Planning review for PPR2235 - V1 - Please address the following items for the Site Plan

COLORADO KIDS RANCH LANDSCAPE PLAN

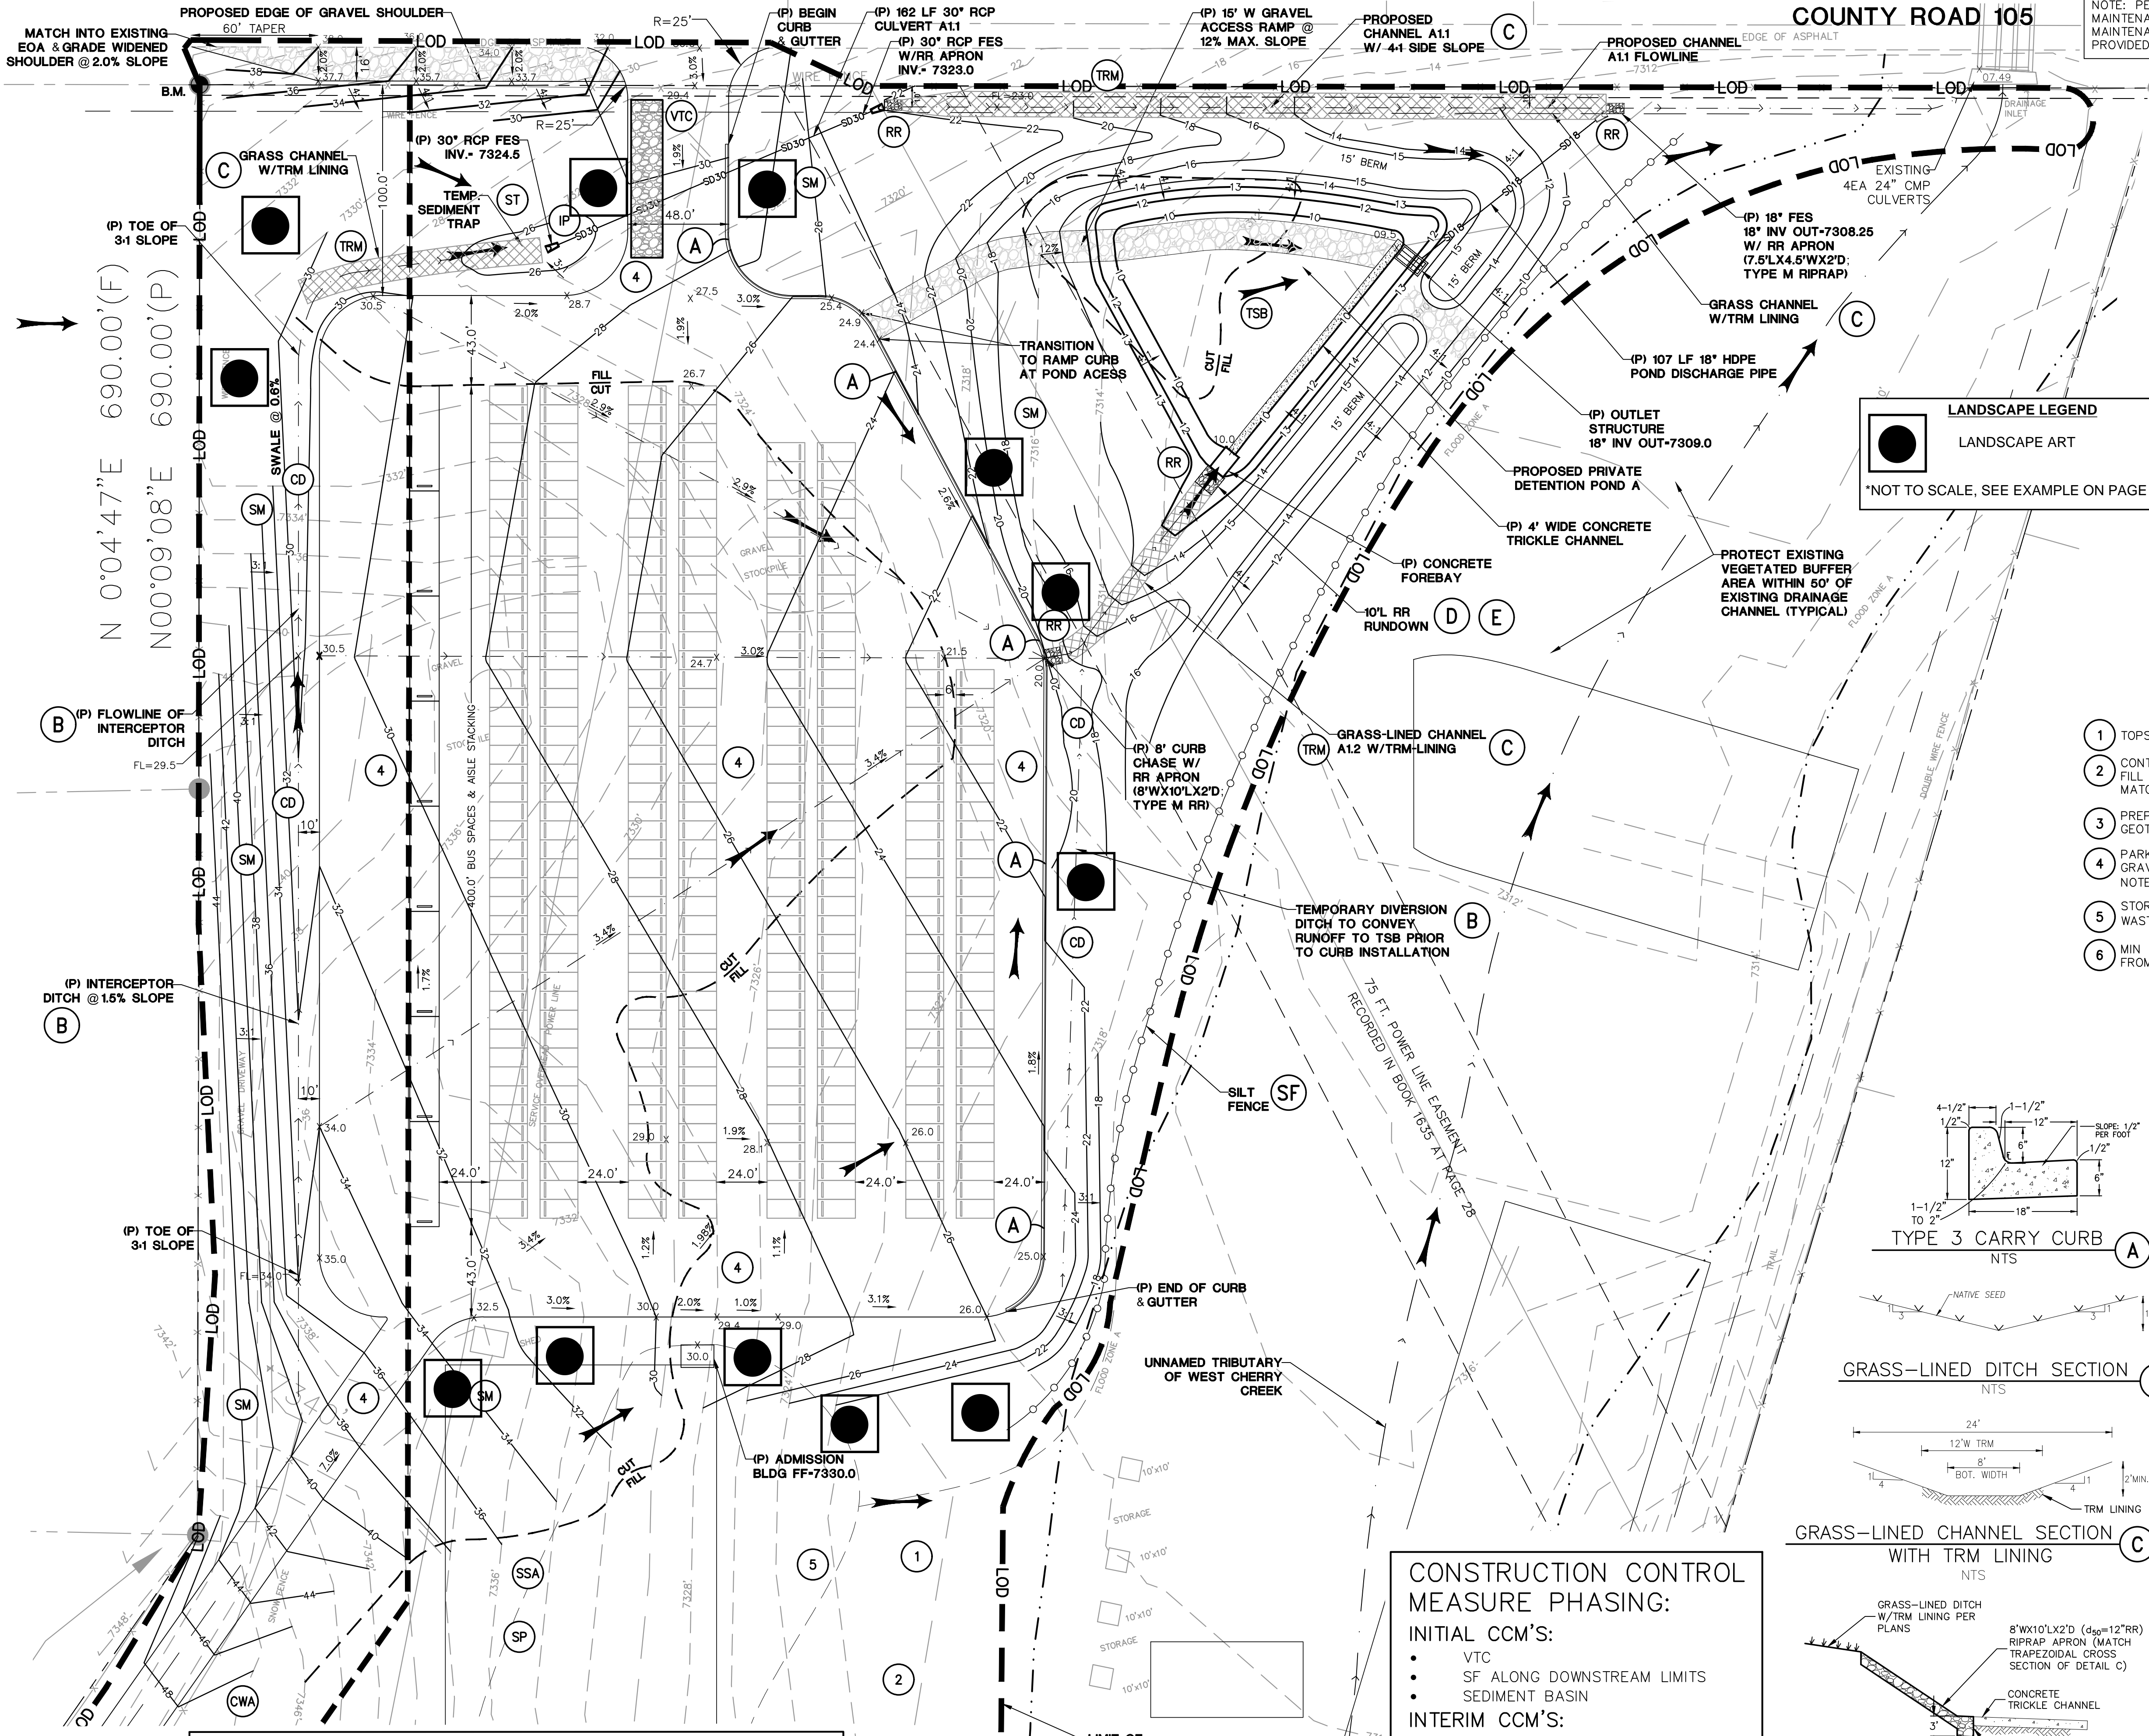
1. Include a first page with the following informational items: Owner name and email for responsible party
2. Property address
3. Property tax schedule number
4. Parking computations (required, provided, etc.) Max 50 cars for this use.
5. Lot/parcel size
6. Lot area coverage calculation
7. Total gross building square footage

1. Date, north arrow, and a graphic scale
- Vicinity map showing the subdivision in relation to section lines and existing or proposed arterial or collector roadways.

2. Location and dimension of all property lines, rights-of-way, and all existing and proposed easements - Include ROW to the north
3. The footprint of all existing and proposed buildings and the setback distances from each existing and proposed structure to the property lines

4. Location of all sidewalks, trails, fences and walls, retaining walls, or berms
5. Location and dimensions of all existing and proposed (labeled) signage on site

6. Traffic circulation on site including all points of ingress/egress into the property - how do the visitors get to the parking lot?
7. The layout and location of all off-street parking, loading and other vehicular use areas.

8. Location of existing and proposed water and wastewater infrastructure, including well and septic locations
9. Location of all garbage receptacles with a graphical depiction of the screening mechanism

10. Location of all existing and proposed utility lines and associated infrastructure
11. place the project number at the bottom right of the page (PPR
